Green Hill Solar Farm

EN010170

Statement of Common Ground: Milton Keynes City Council Revision C

Document Reference: EX7/GH8.3.3_C
Infrastructure Planning (Examination Procedure) Rules 2010

Title: Figure 8.10.5 Viewpoint Locations
Green Hill G

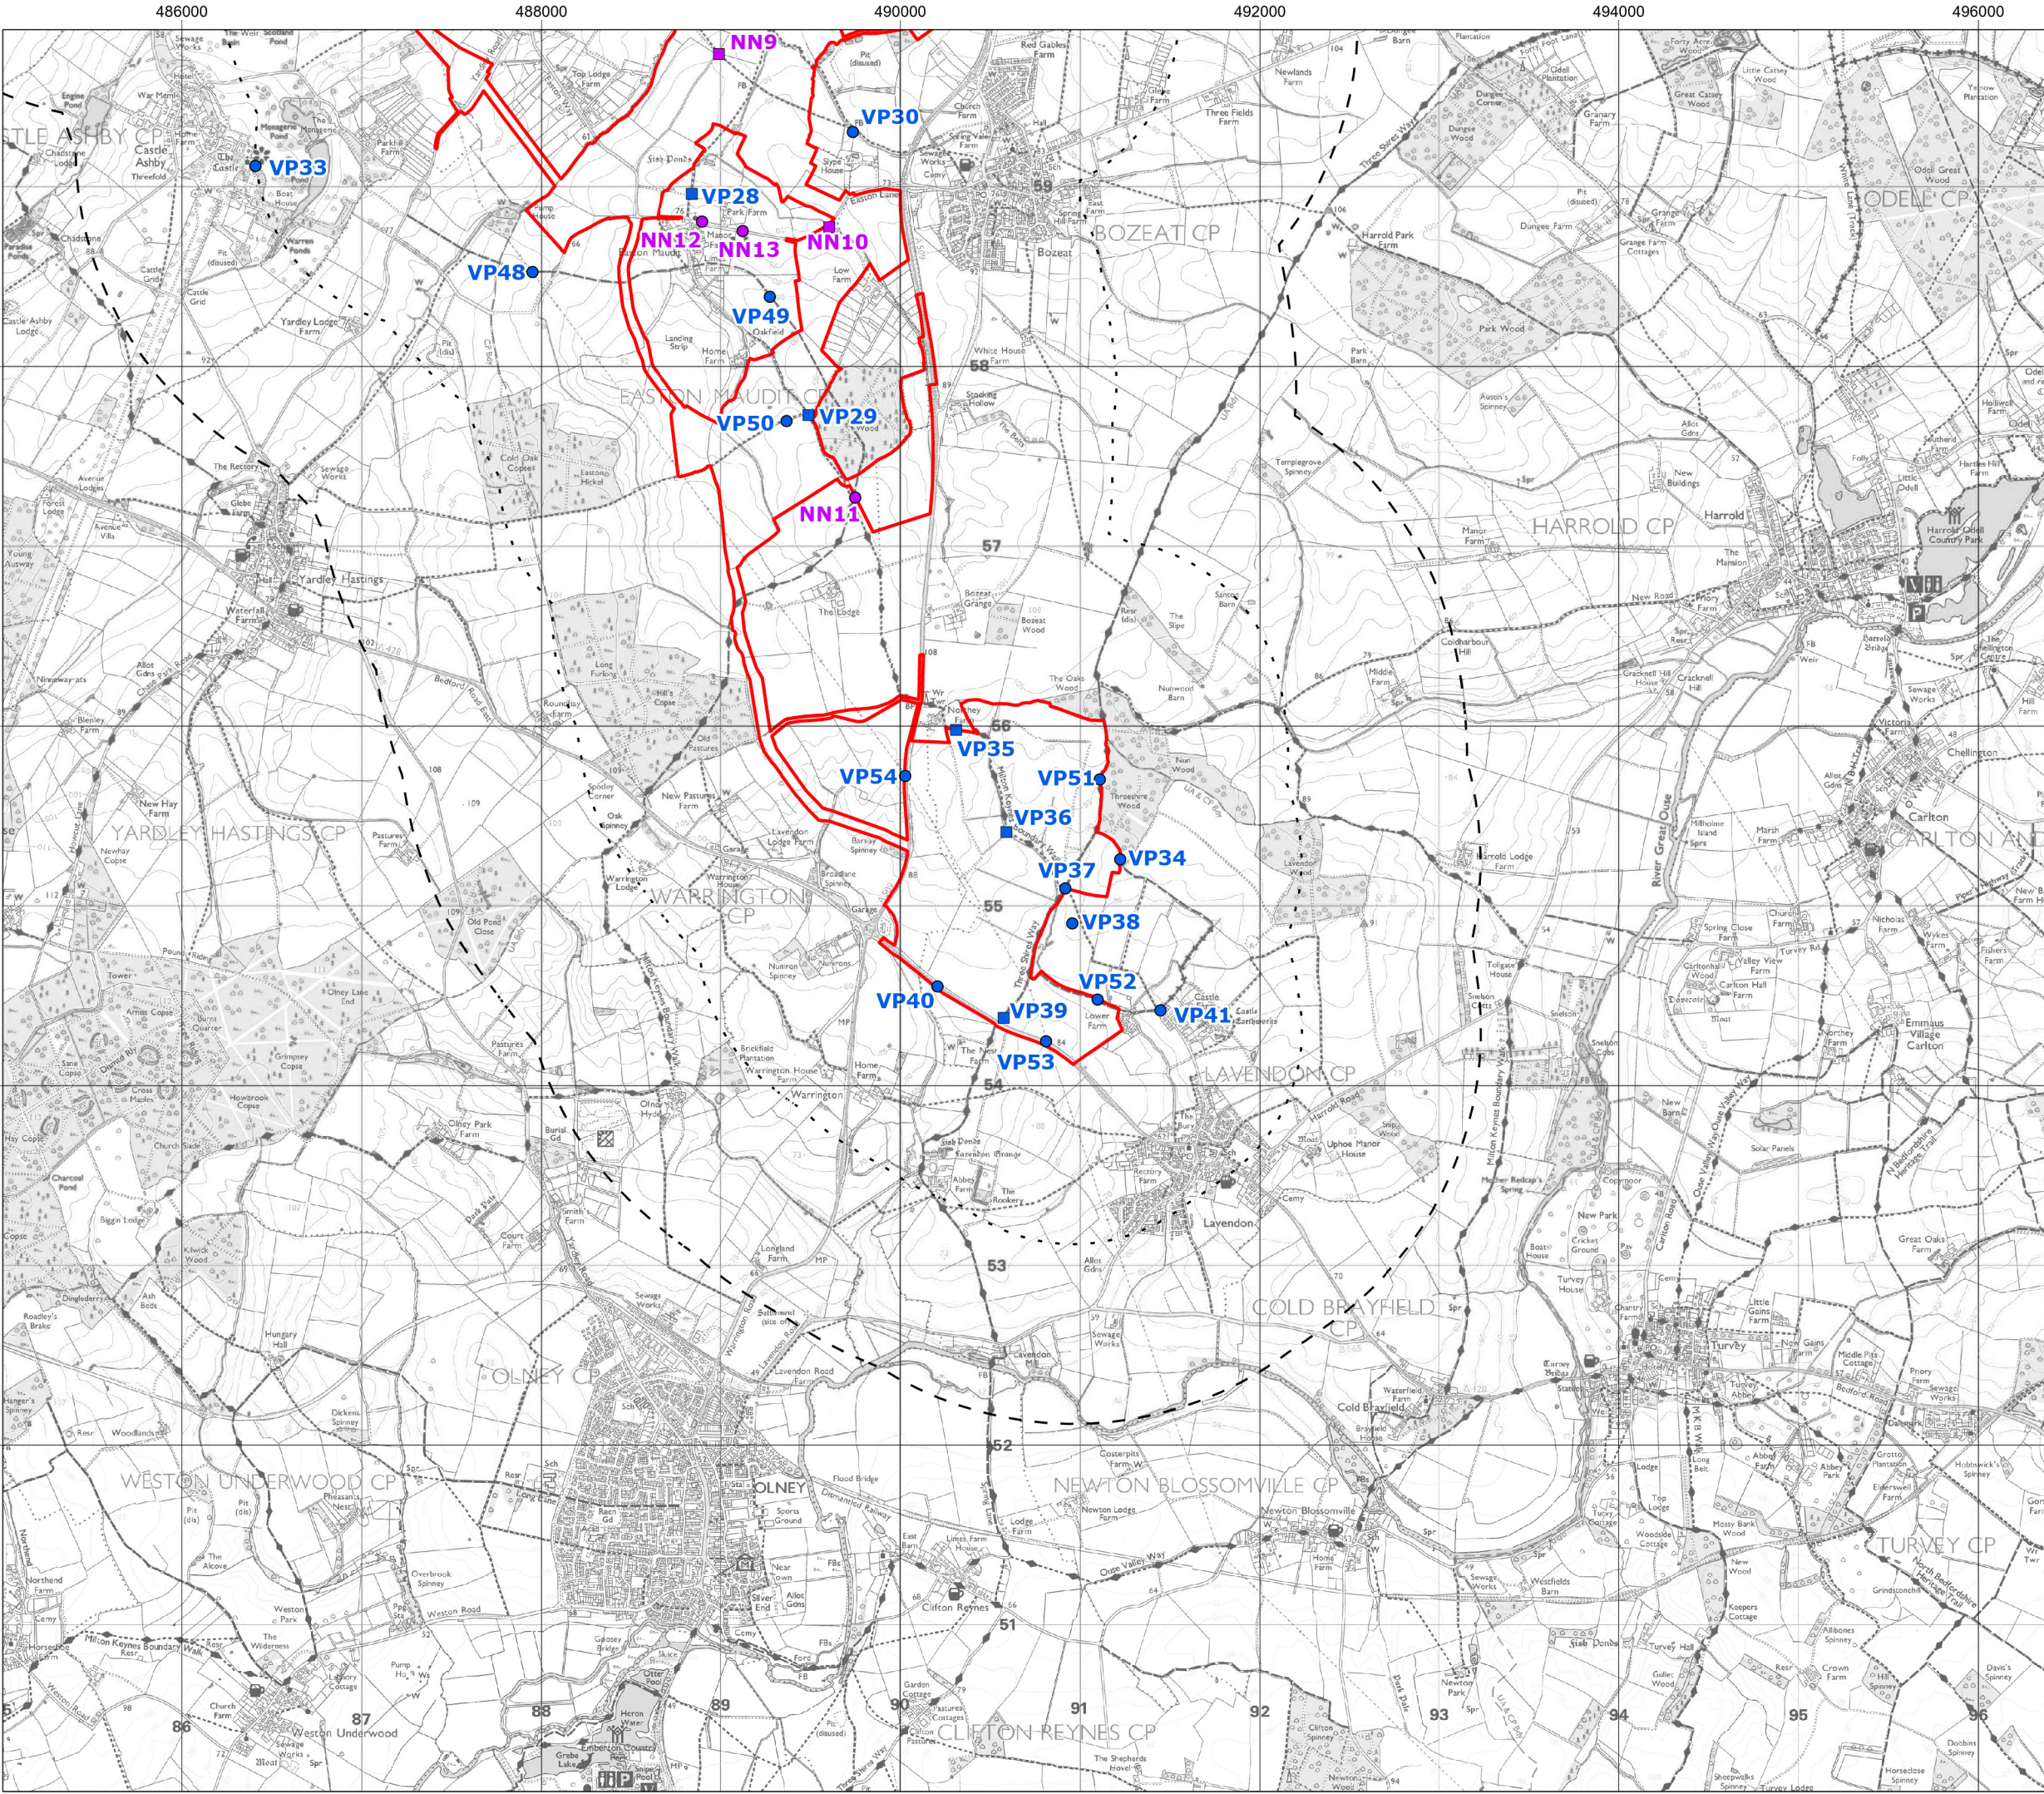
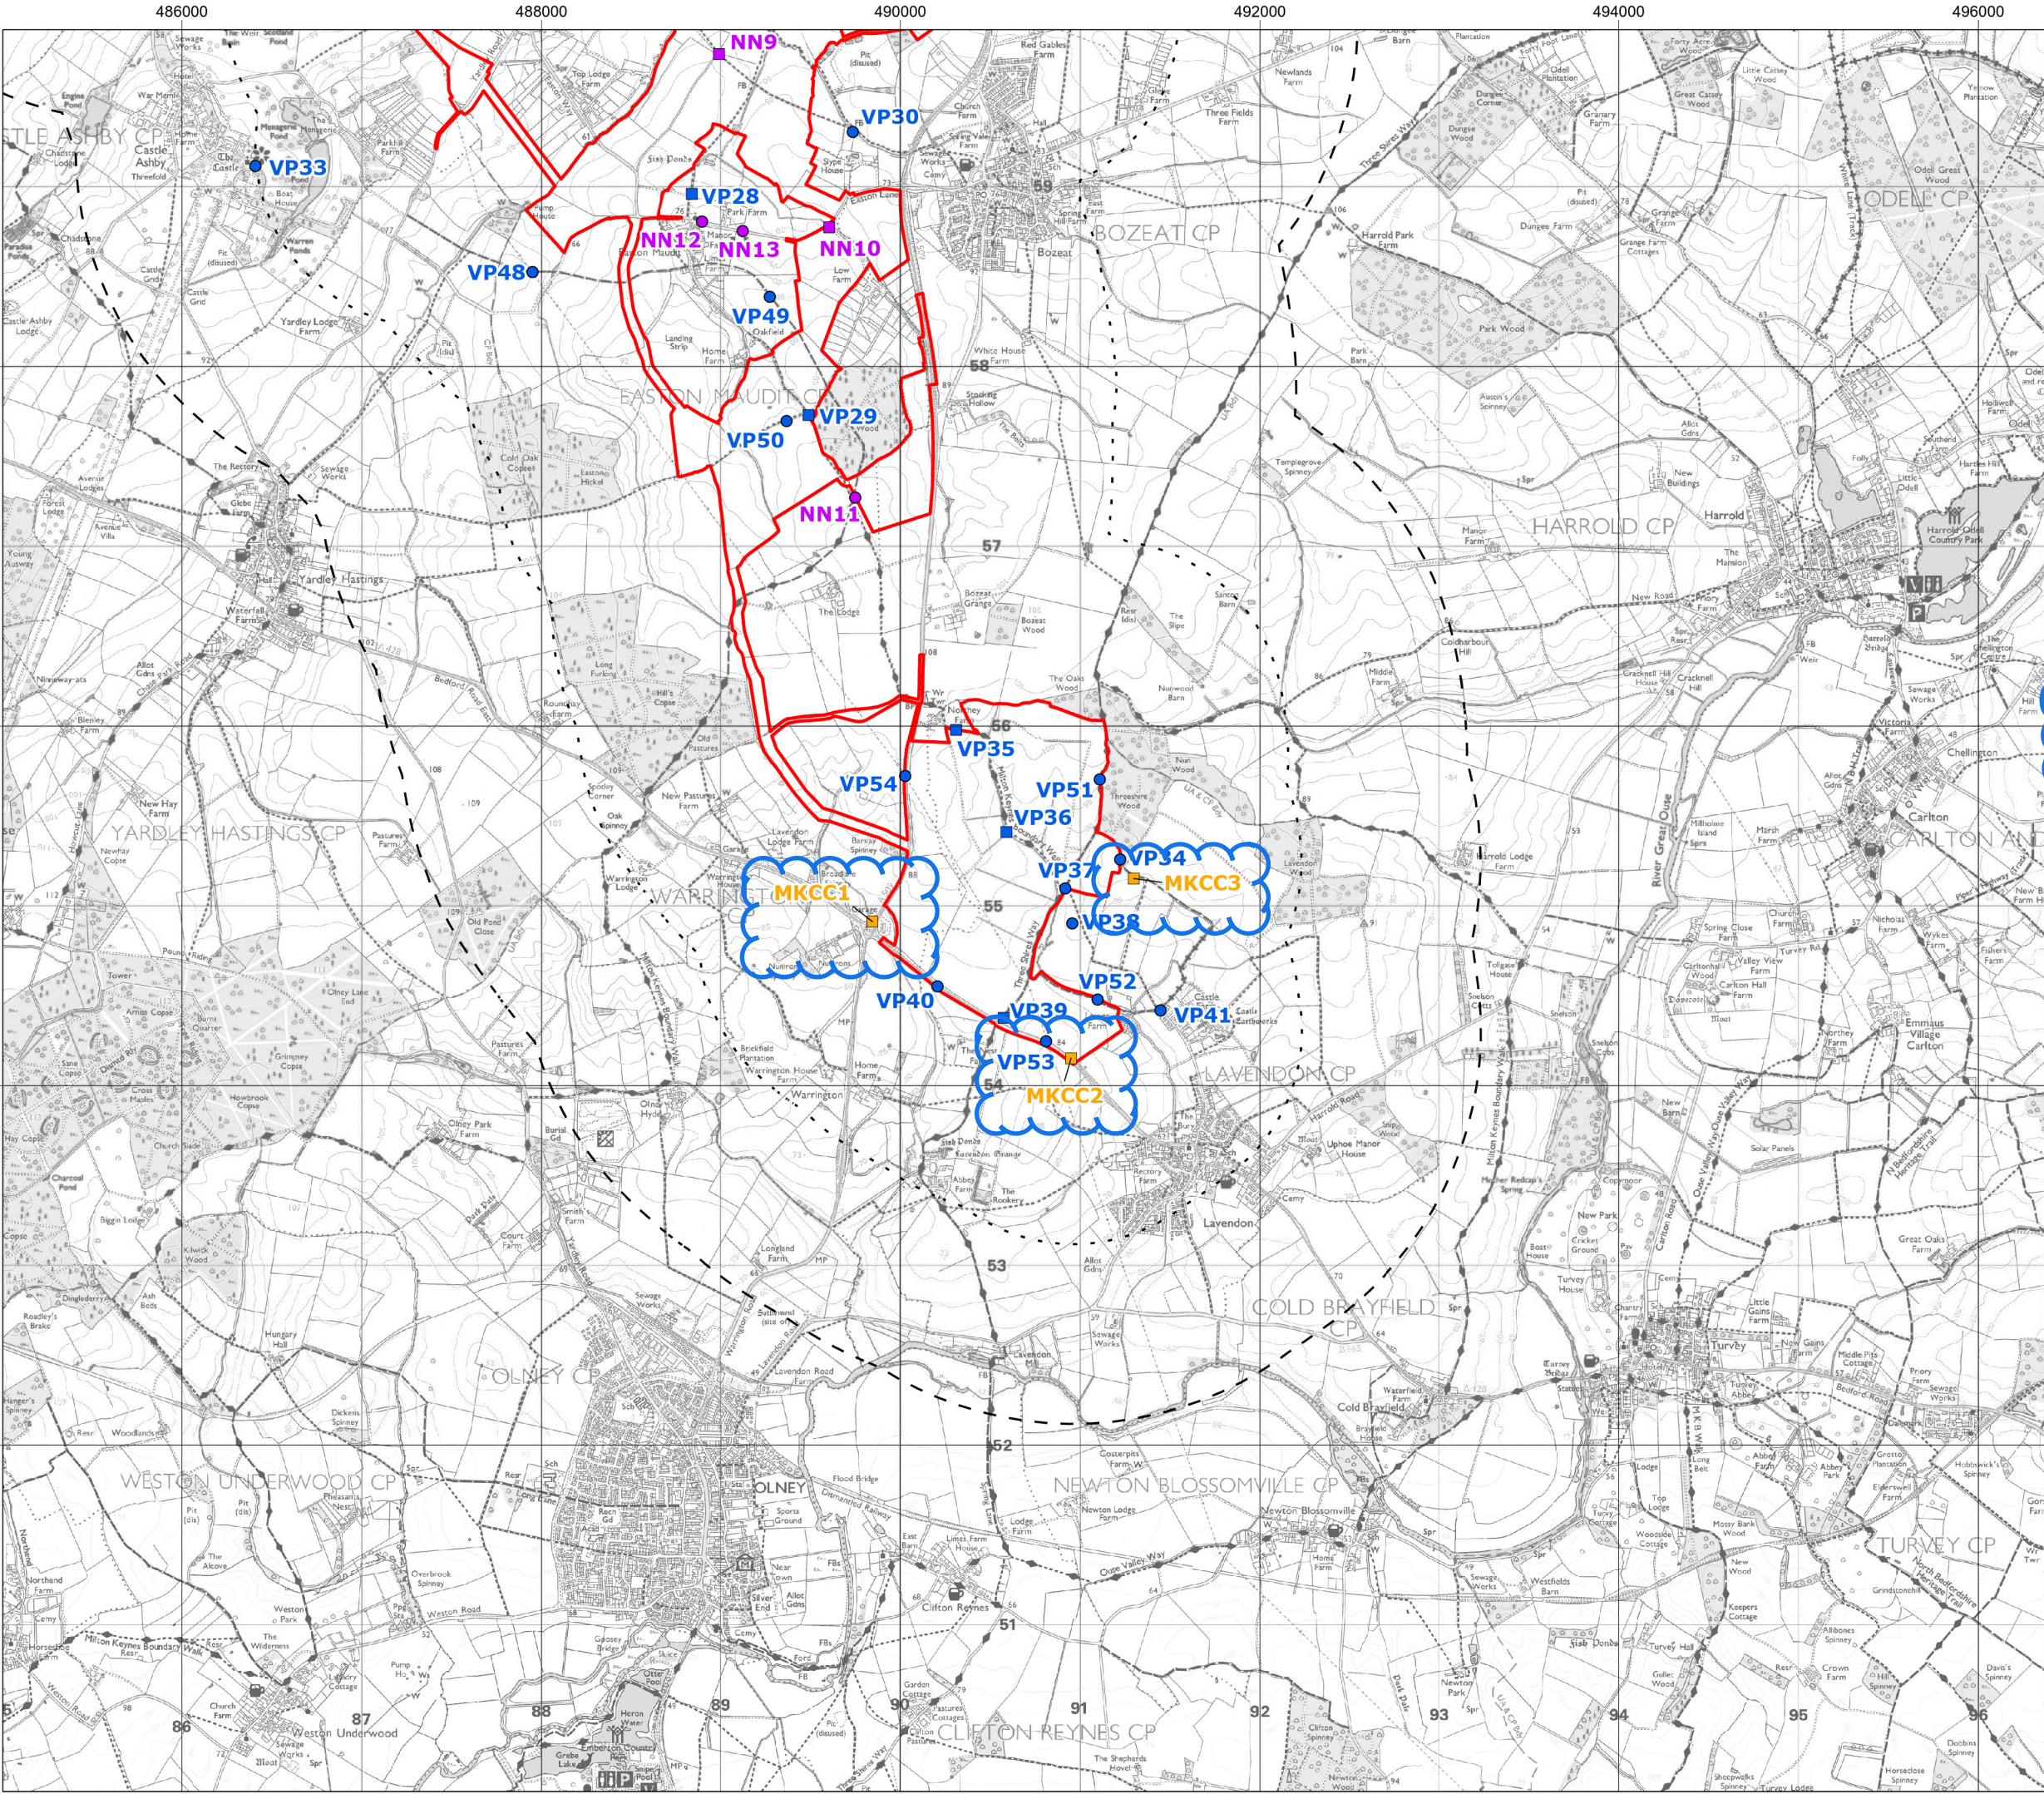
Matter	Details of Matters for Discussion	Applicant Position	Consultee Position	Status
				<p>been accounted for in the ES or included as an appendix to ES Chapter 8: Landscape Character Assessments.</p> <p>MKCC Landscape DM Consultee submitted a formal response on its position to emerging policy during the Reg 19 Consultation.</p> <p>Comments as per LIR</p>	
LVIA-07	Visual Receptors: Assessment Viewpoints for the Sites	ES Chapter 8: Landscape and Visual [APP-045]	<p>The viewpoints set out within Table 8.5 in section 8.7 of ES Chapter 8: Landscape and Visual [APP-045] and ES Chapter 8: Figure 8.10 [APP-308] are considered acceptable to inform the assessment baseline conditions.</p> <p>Applicant’s Response to the Consultee</p> <p>The viewpoints were submitted at Deadline 5 [REP5-094 and REP5-095]. The ES Figure 8.10 Viewpoint Locations [REP5-041] were updated to reflect this additional viewpoint at Deadline 5</p>	Requested additional viewpoints were discussed on 28th January 2026 and are acceptable. Photomontages of additional VPs are not yet shown on Figure 8.10 [APP-308].	Matter Disagreed

Matter	Details of Matters for Discussion	Applicant Position	Consultee Position	Status
			<p>with ES Figure 8.10.5 Viewpoint Locations Green Hill G [REP5-045] also updated at Deadline 5. The Applicant has also submitted at Deadline 6 an additional photomontage for viewpoint 51 at Green Hill G [REP6-073] as requested by the Examining Authority in Q3.10.13 of the Examining Authority’s Written Questions 3 [PD-017]. This was sent to MKCC landscape and planning officers on the 18 March 2026 but no response/comment has been provided to date.</p>	<p>Updated Consultee Position</p> <p>As of 20/03/2026, the locations of additional VPs and photomontages shown on [GH8.2.15-MKCC2 and GH8.2.16-MKCC3] are not yet shown on Figure 8.10 [APP-308] held against Green Hill Solar Farm Examination Library Updated – 18 March 2026. We have been provided with links to correct documents in an email from MKCC planning but it is not possible to find these on the website examination library by searching under APP-308.</p>
